# TRAFFIC IMPACT STUDY

**Owl Place Commercial  
El Paso County, Colorado  
PCD File No. CR221**

June 2022  
Revised:  
January 2023

**Figure 4A**  
**BACKGROUND TRAFFIC - YEAR 2024**  
 Volumes  
 AM / PM Peak Hour  
 (ADT) : Average Daily Traffic

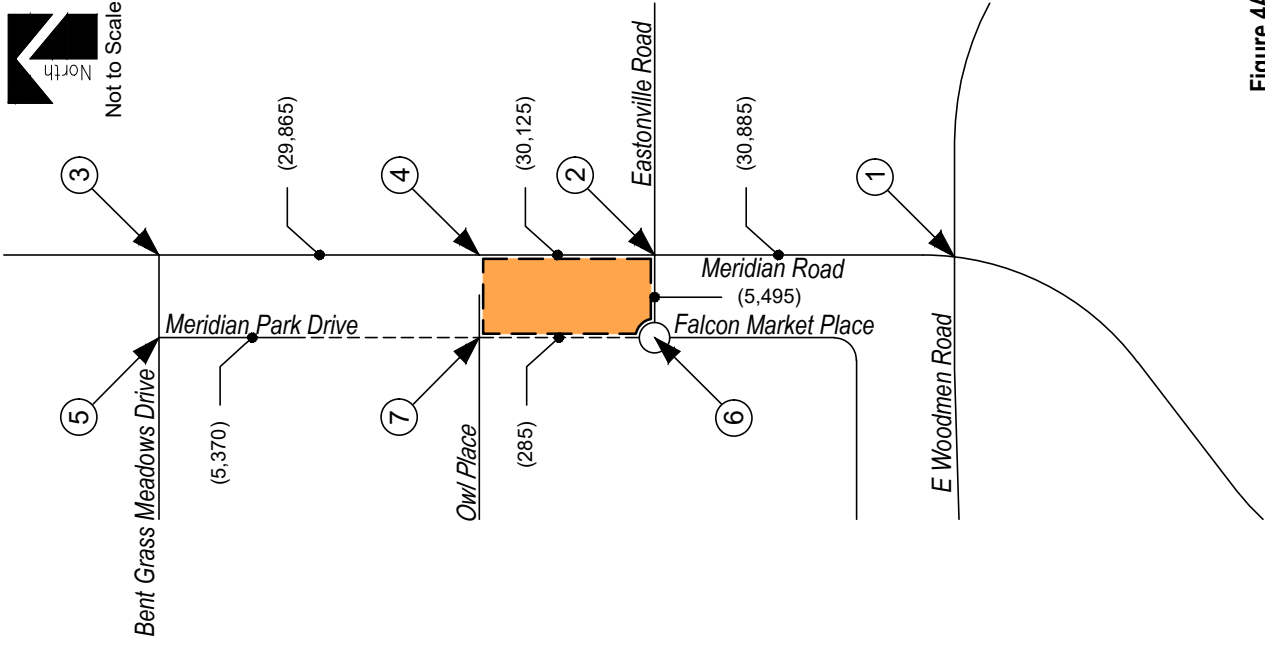
Does not appear to account for traffic from approved Bent Grass east commercial (SP2010 & SF2147) traffic as the TIS for that site indicates +5K trips along meridian park drive.

**Figure 5A**  
**BACKGROUND TRAFFIC - YEAR 2040**  
 Volumes  
 AM / PM Peak Hour  
 (ADT) : Average Daily Traffic

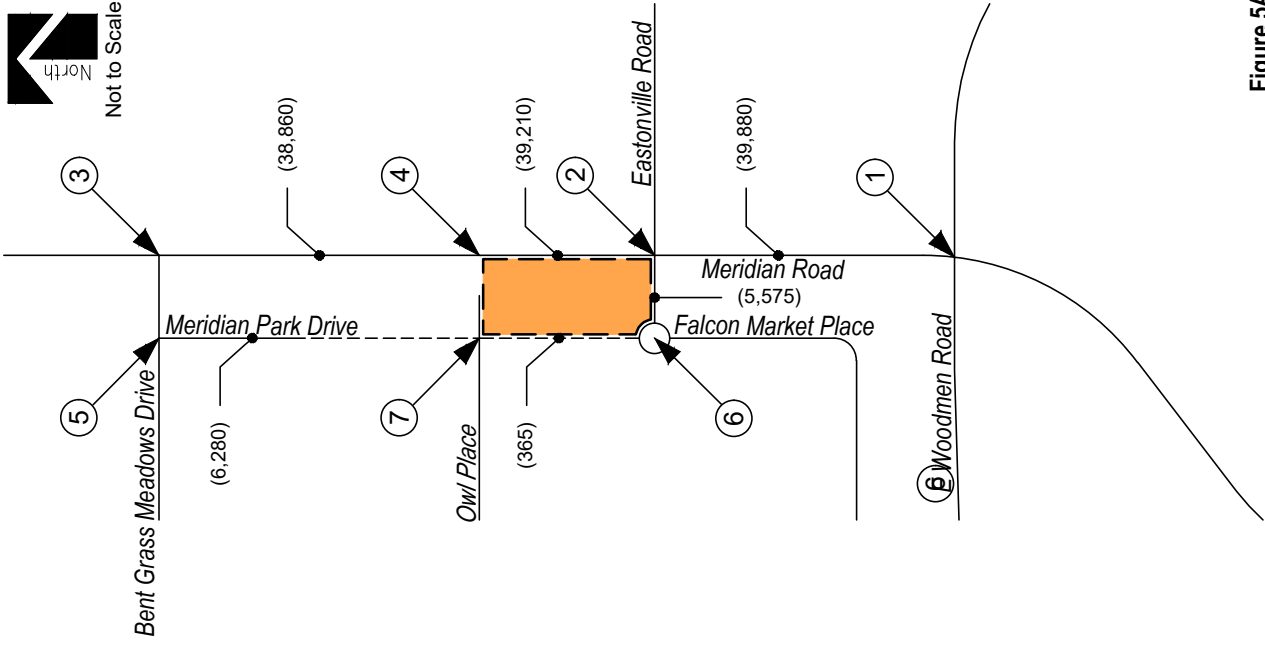
Staff requested analyses with both scenarios where this intersection is closed or RI/RO only. If only one analysis is provided it should be without the RI/RO to address potential effects on the surrounding intersections.

Provide link ADT here on all figures
